Please ask for: Mrs D Johnson
Email: daun.johnson@arun.gov.uk
Telephone: 01903 737762
Our Ref: A/157/21/DOC
Your Ref:
Date: 15th August 2021

Approval of matters reserved by condition

Development: Approval of details reserved by condition imposed under A/125/13/ relating to condition 17-landscape scheme.
Location: Chandlers Bmw Worthing Manor Retail Park Rustington BN163FH

scheme: Mill Lane Site
client: Store Property
drawing: Landscape Proposals
date: Sep '13
scale: 1:200@A1
drawing no: STORE18832 13A
drawn: DKM checked: AW

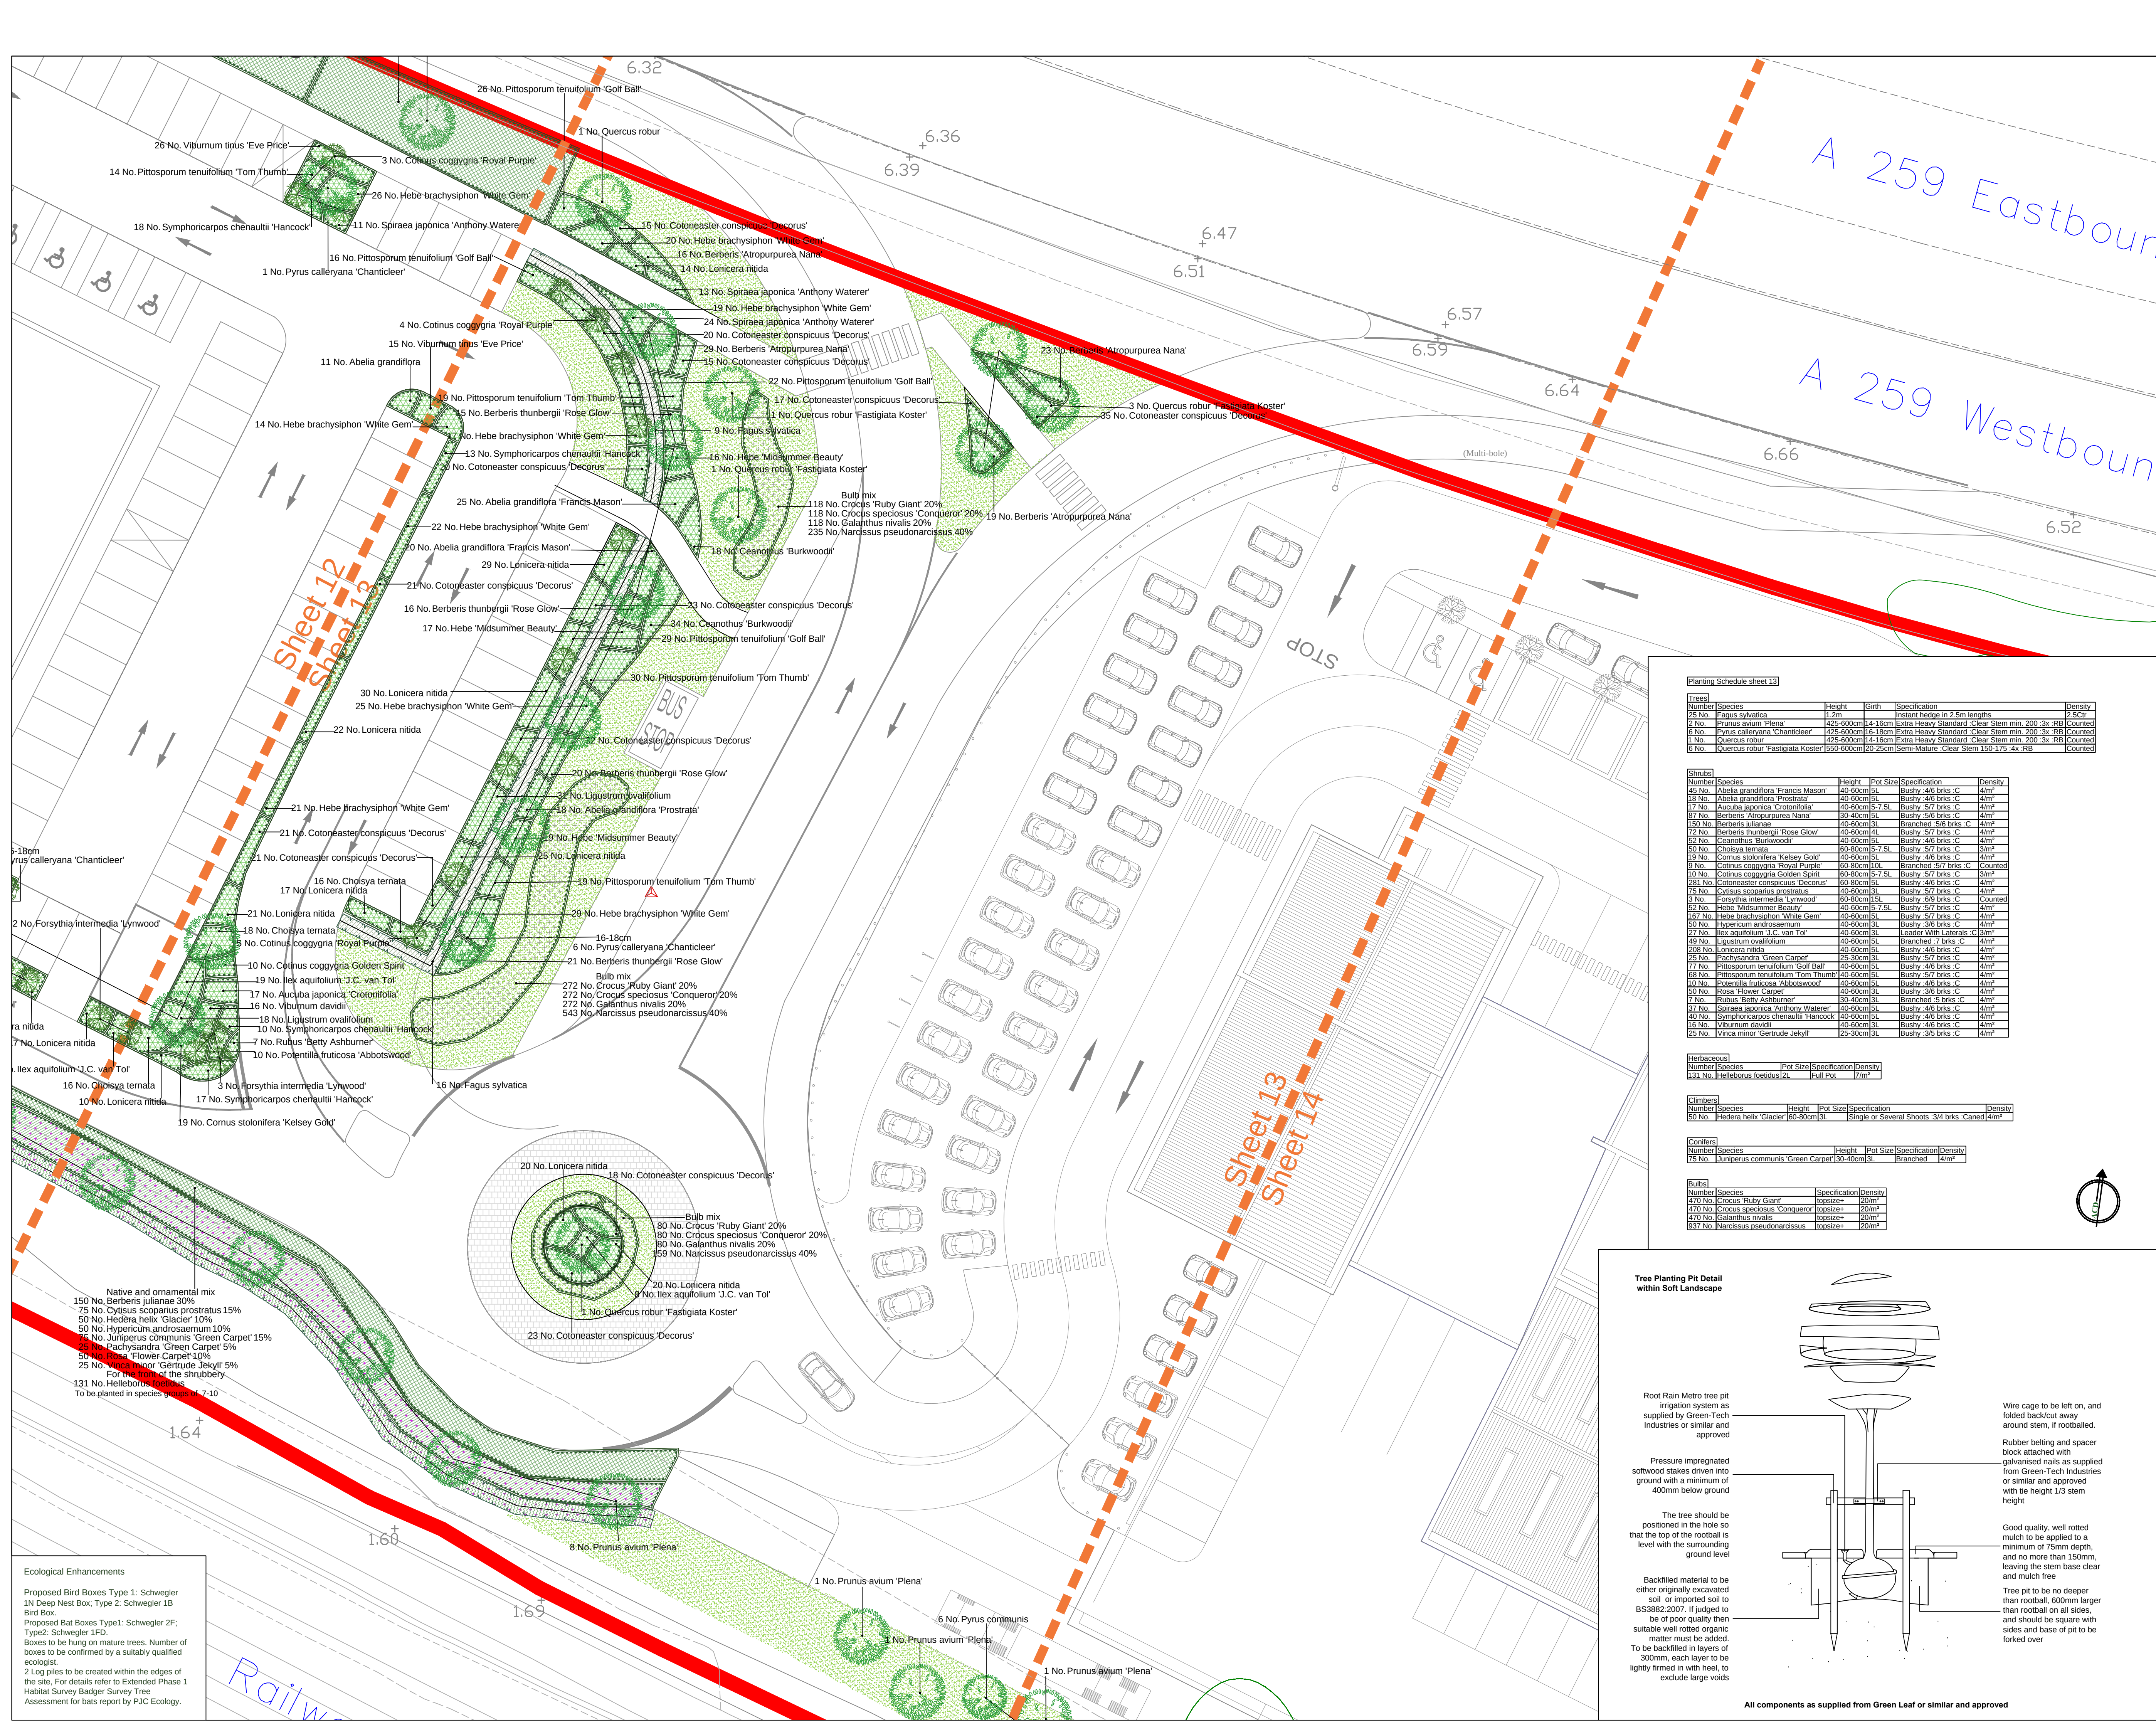
It would also be useful if they provide a copy of the landscaping plan approved under A/112/14/DOC so that all proposed changes to the scheme are clear.

Planting Plan 1 of 2

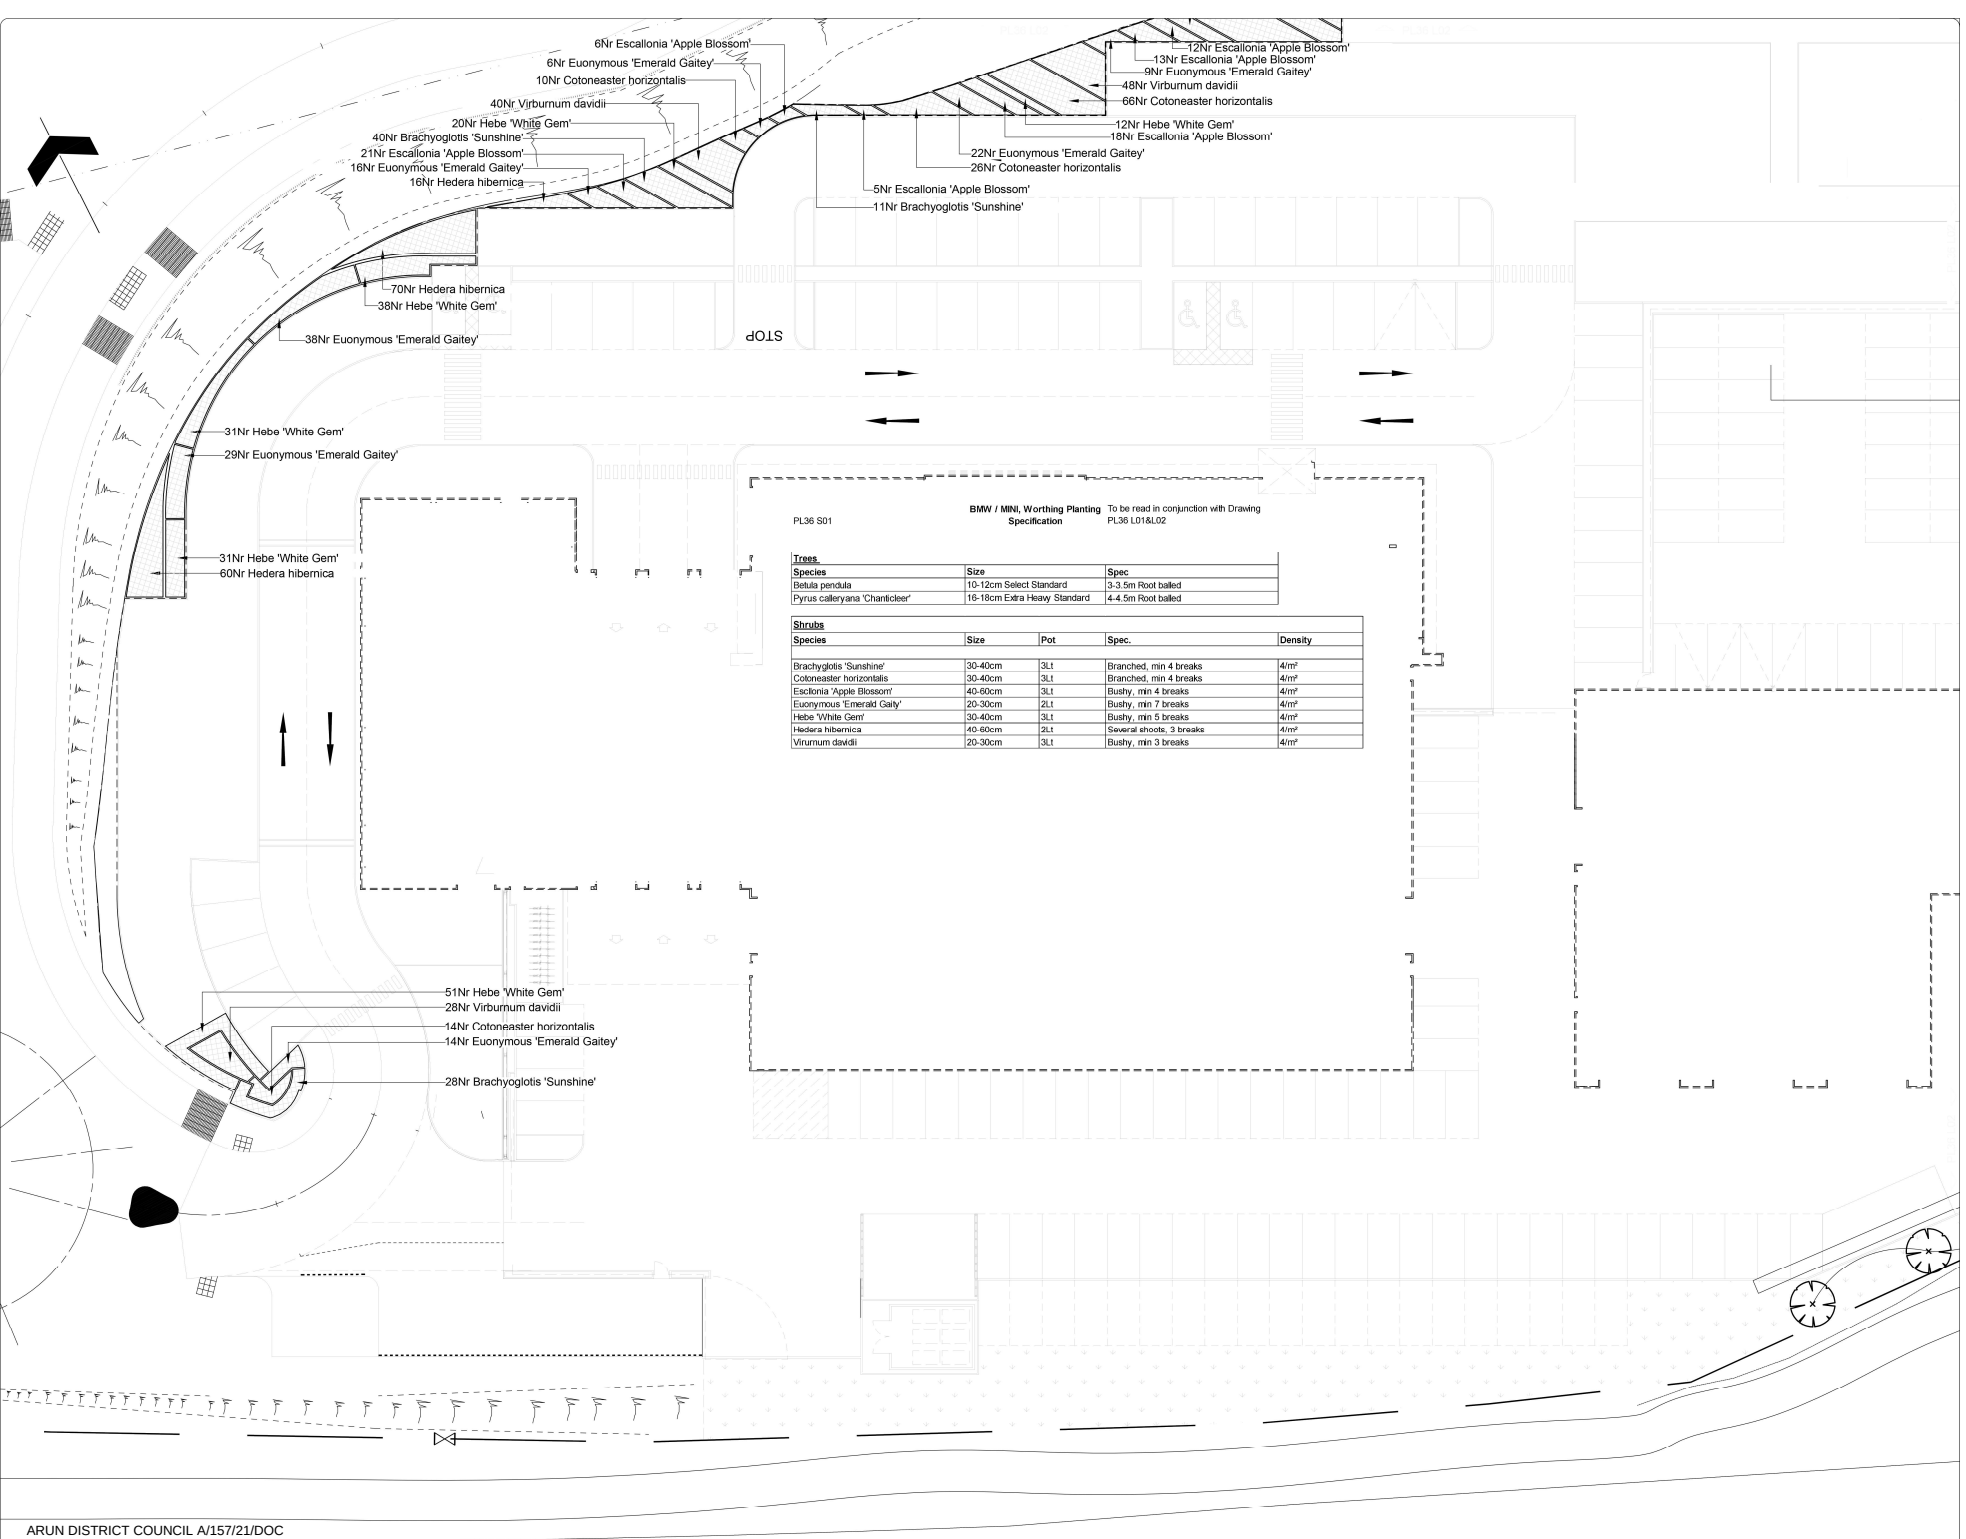
For the purposes of compliance, the red edge to the location and site plans needs to be enlarged to coincide with the previous approvals A/112/14/DOC & A/125/13. A detailed landscaping plan is required and needs to set out the areas of planting previously undertaken to the rear of the site, the alterations where hard landscaping has altered and planting would not now be accessible, and the details for the new planting proposed for the remainder of the site together with a schedule thereof.
